The Faversham Society

CHSP Examination

Submission to Issue Specific Hearing on the Development Consent Order 18 July 2019

**Indicative Electrical Compound
(Battery Pack)**
Figure 5.6a

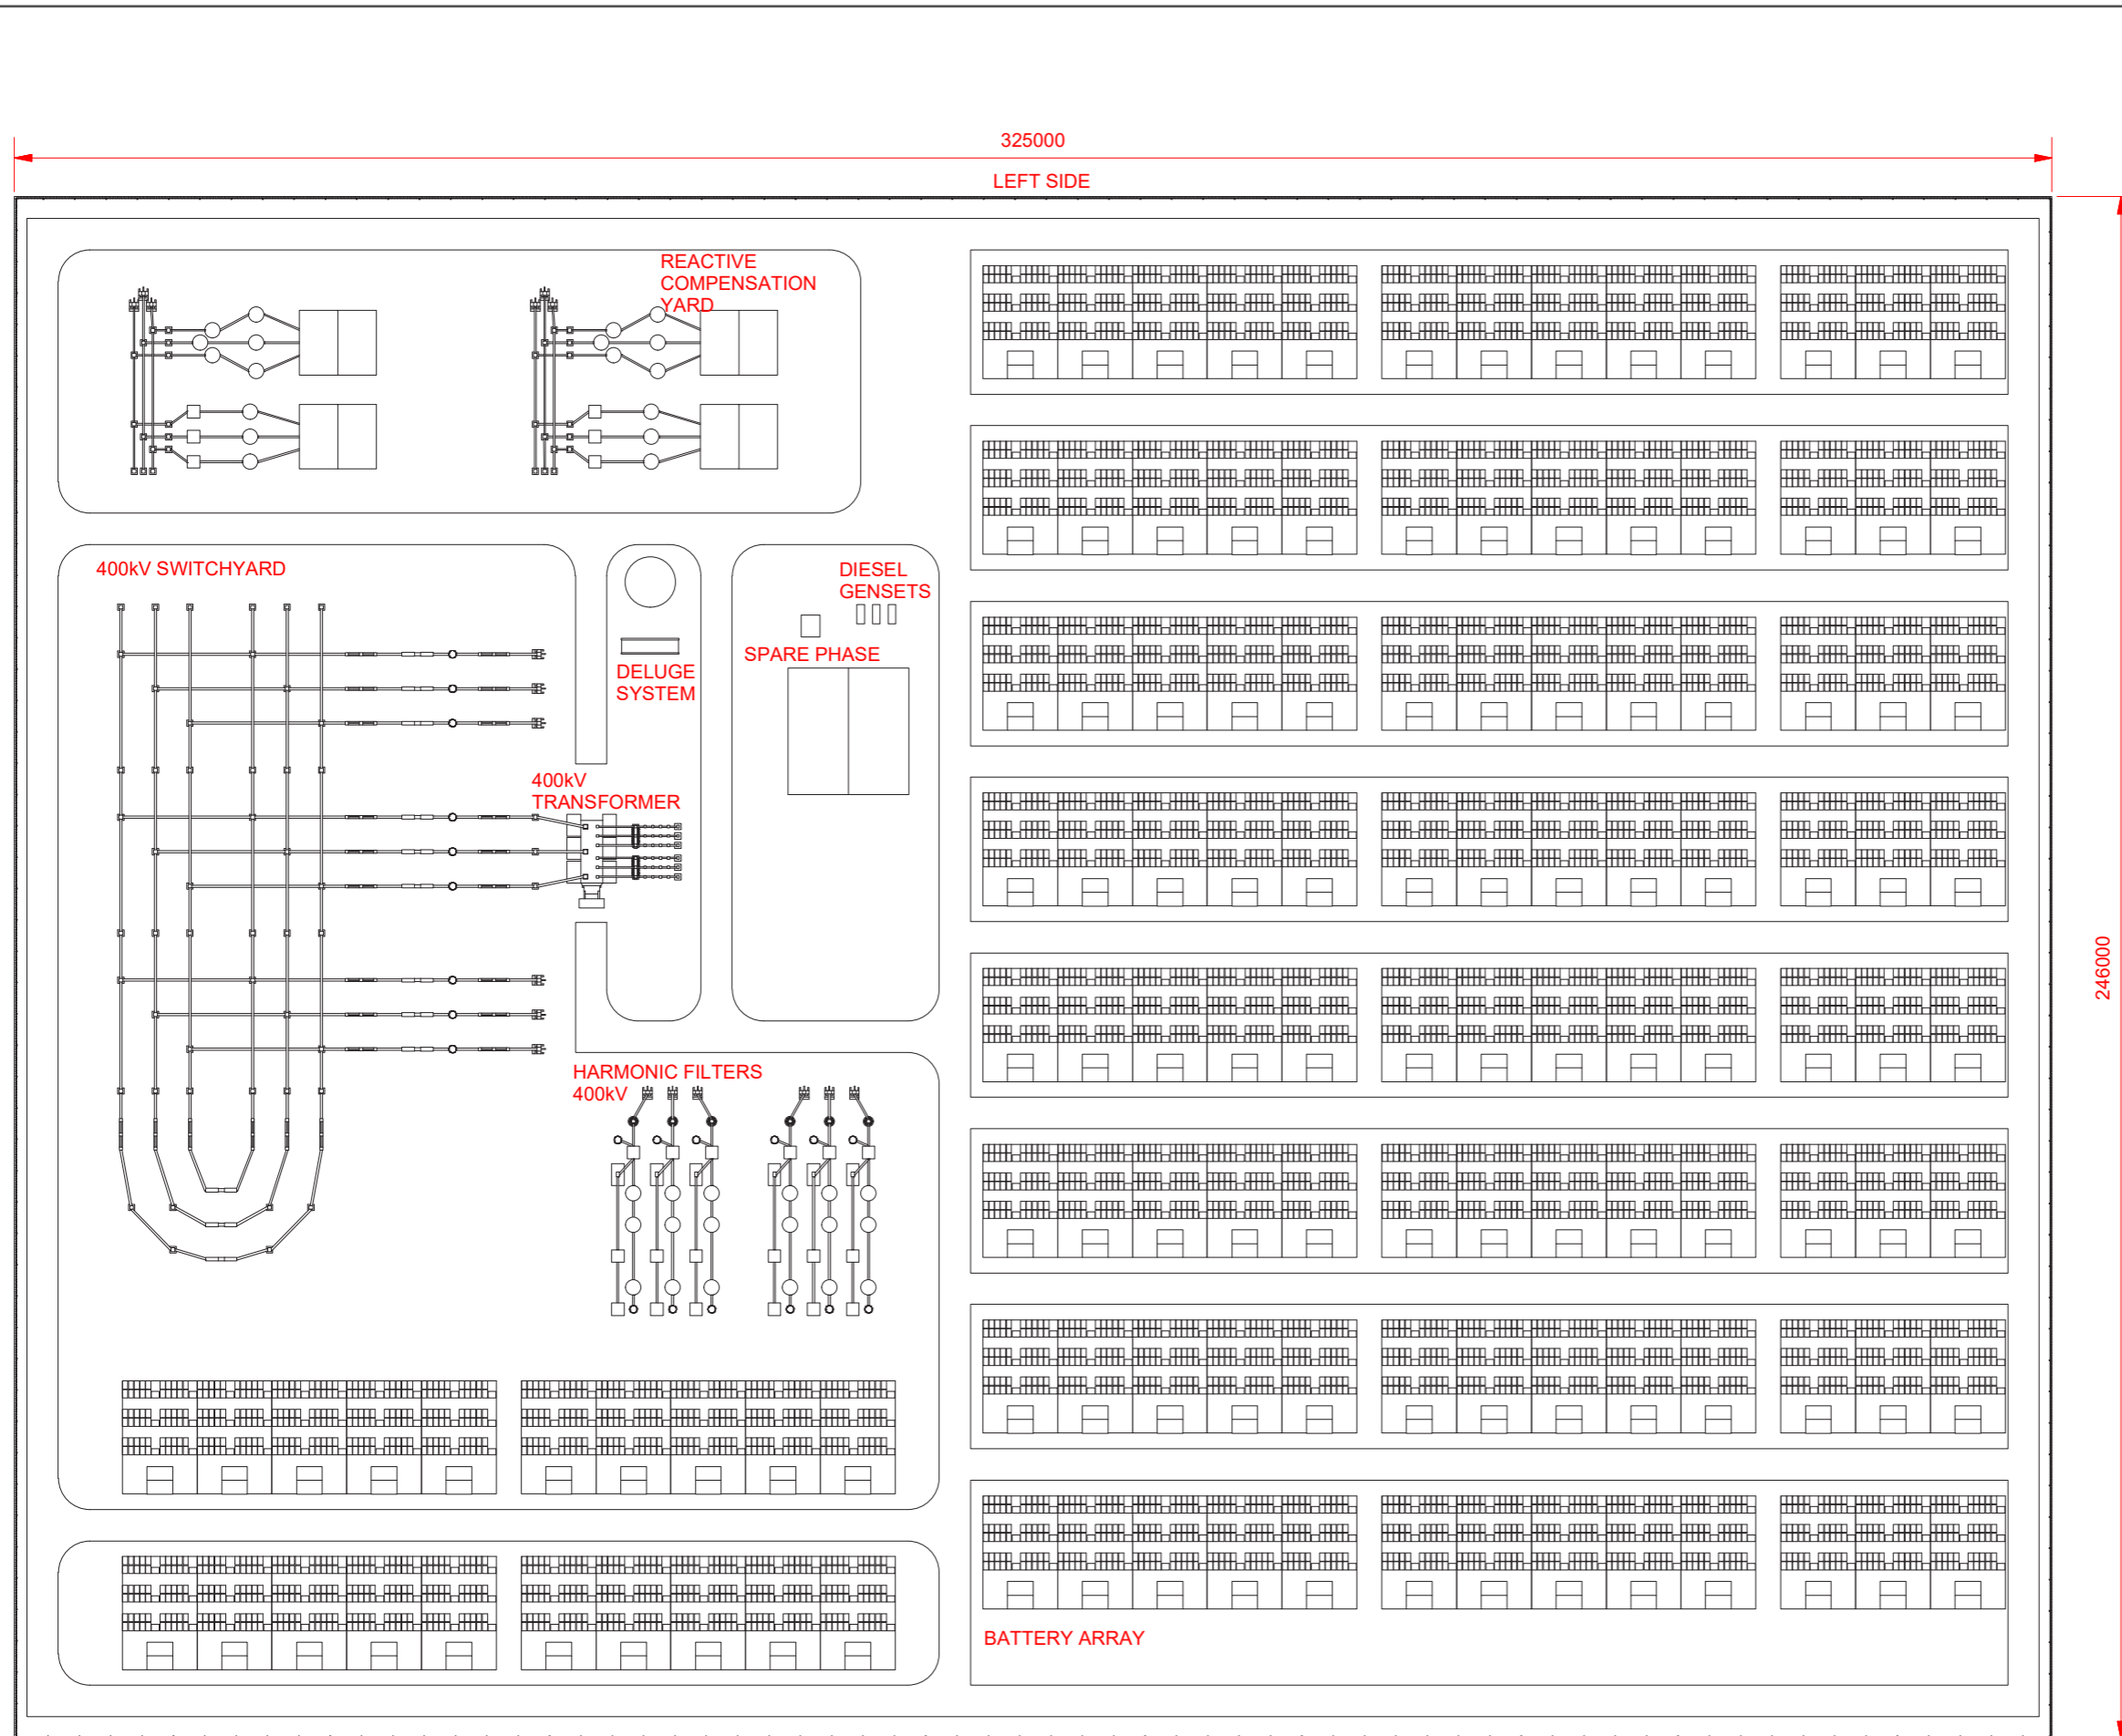
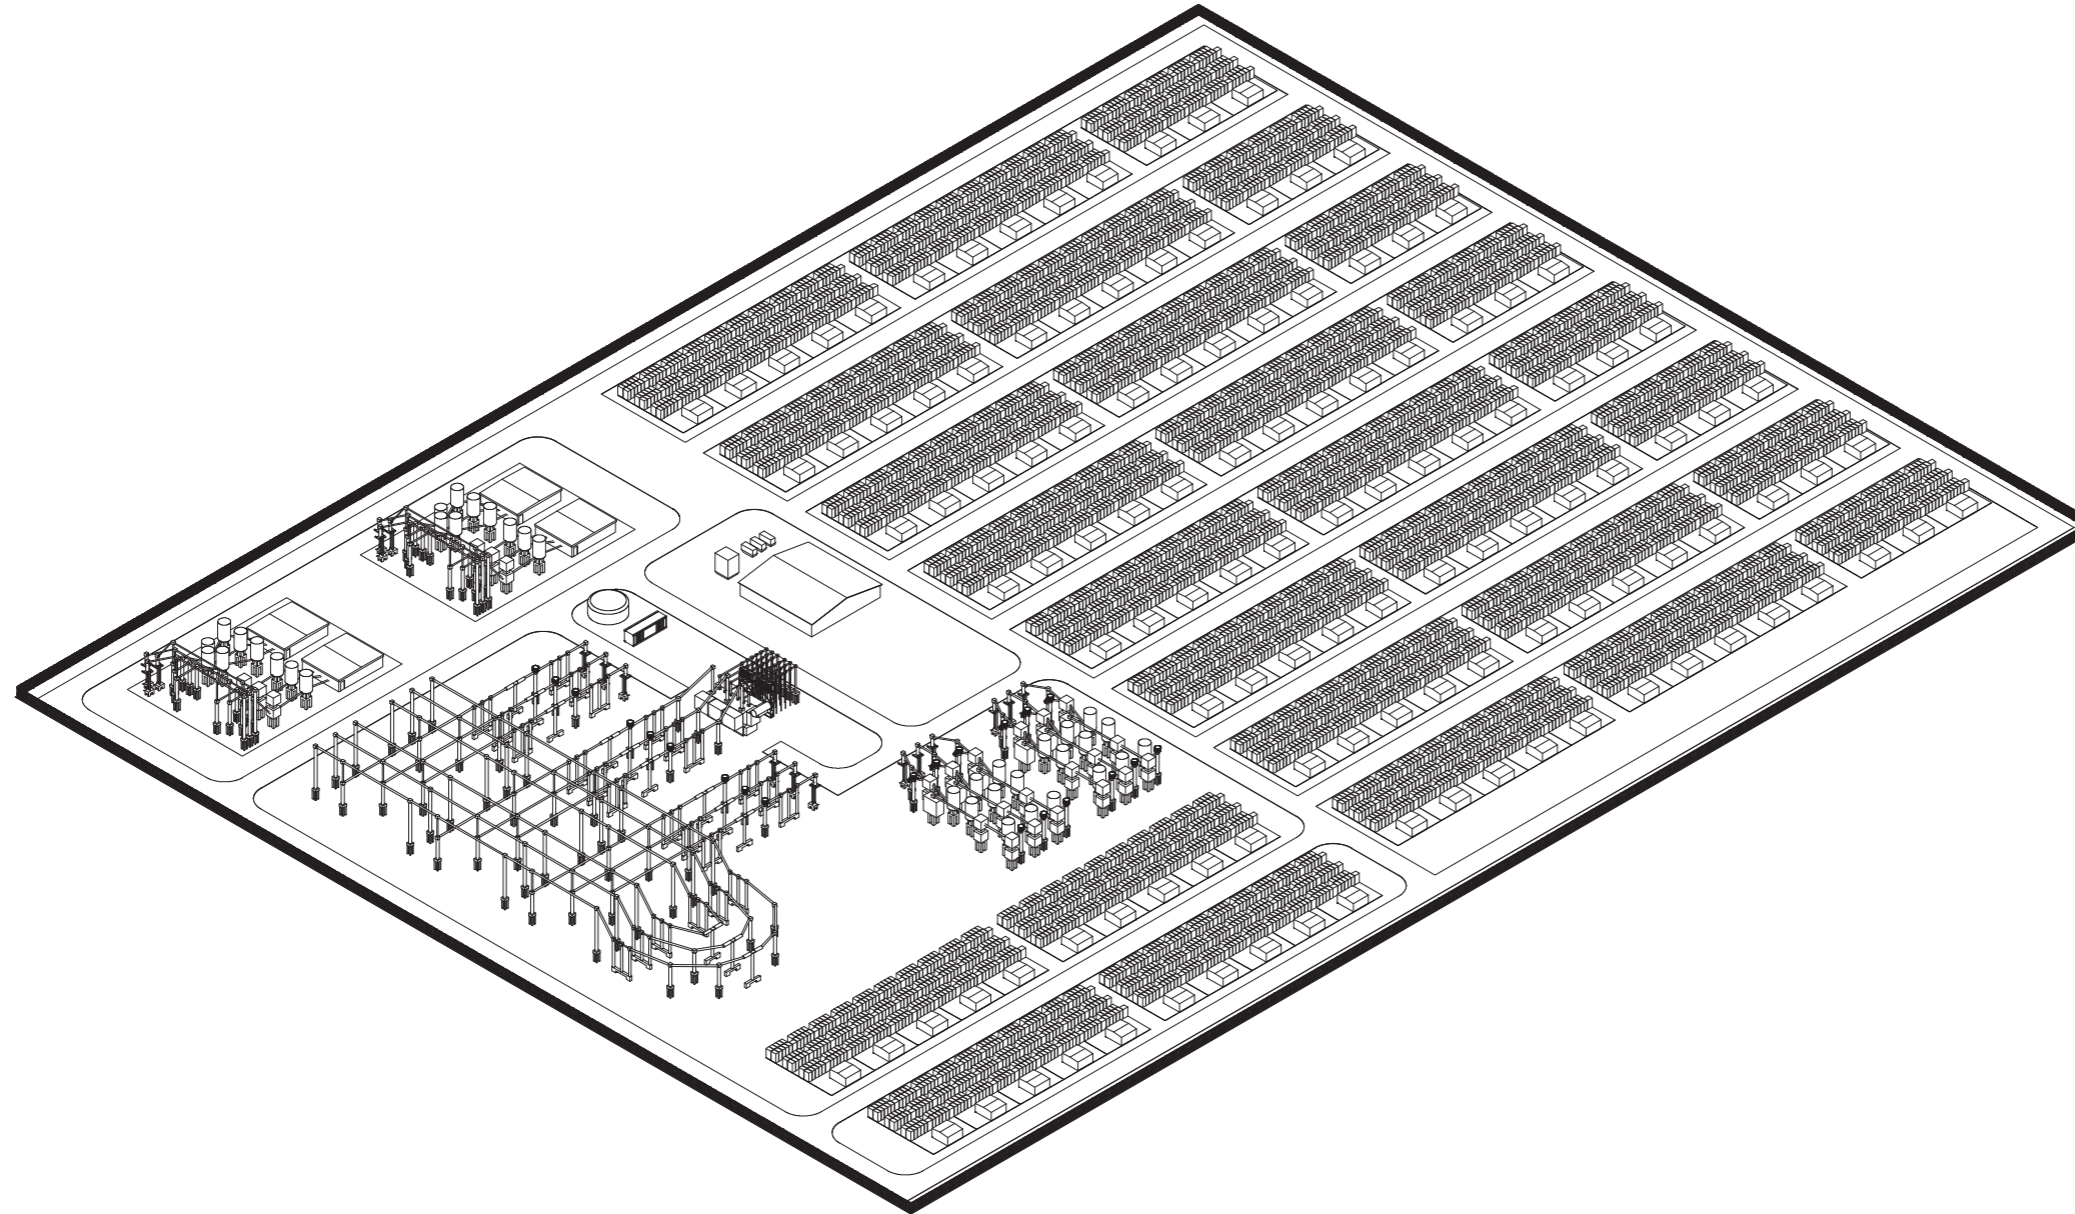
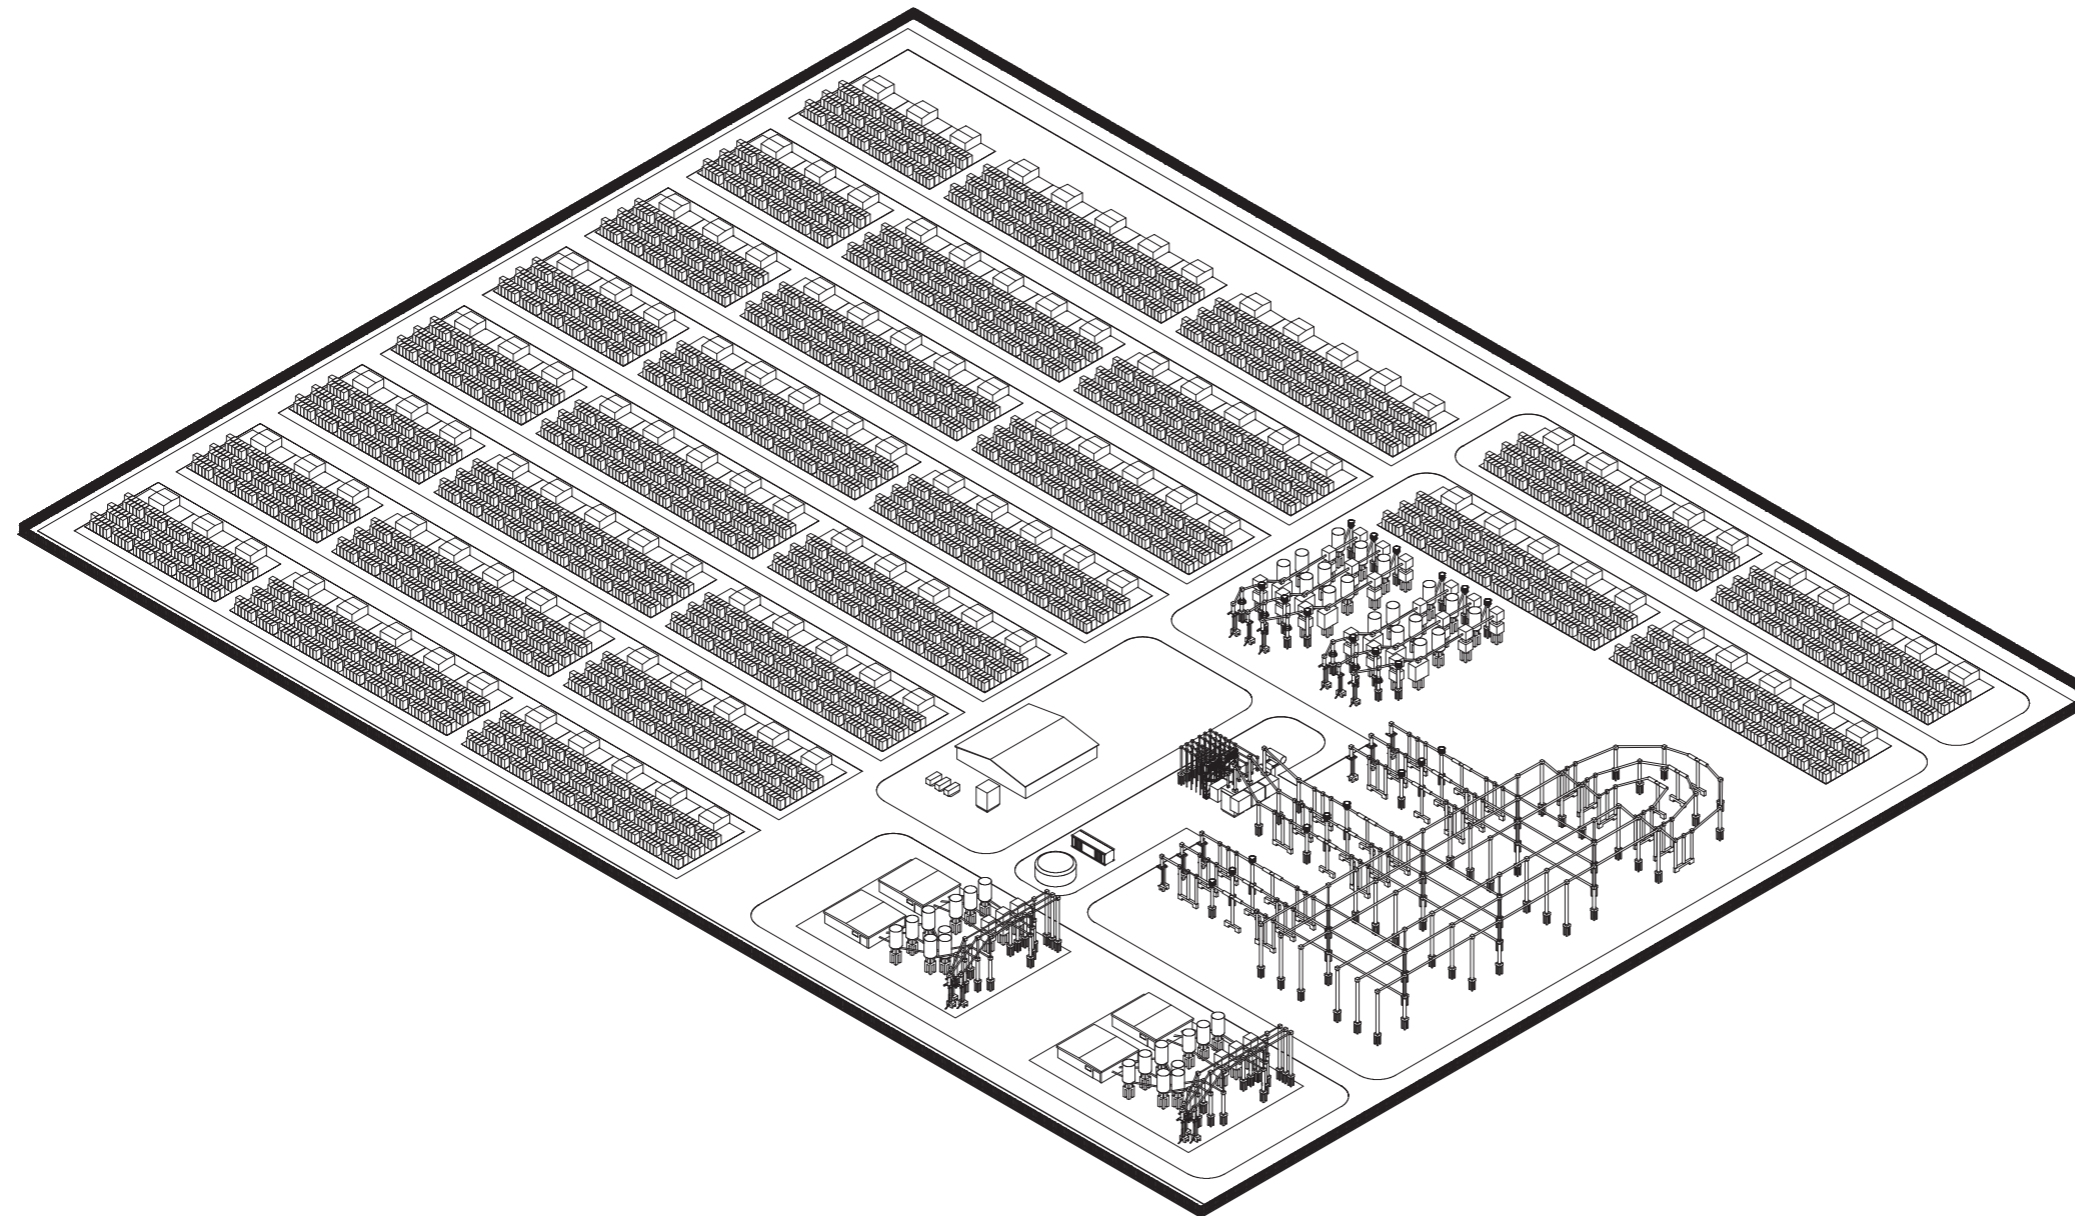
1. We have a number of concerns about the content of the DCO and about how compliance will be assured.
2. We have concerns about the limitations of the Rochdale Envelope about hazards associated with emerging battery technology. The application lacks detail on the battery technology to be installed. Li-ion batteries are potentially hazardous.

3. It is not clear from the developer's plans how the Fire Service would secure access to the battery storage area or effectively fight a fire within the compound, remembering that the compound is comparable in size to the Faversham recreation ground. We believe that the DCO should require the specification of all access routes.

6. There is no acknowledgement or proposed mitigation measures for the risk of a small fire spreading to other cells and becoming catastrophic with highly toxic emissions of Hydrogen Fluoride gas from burning Li-ion batteries in the air over Faversham or Graveney?
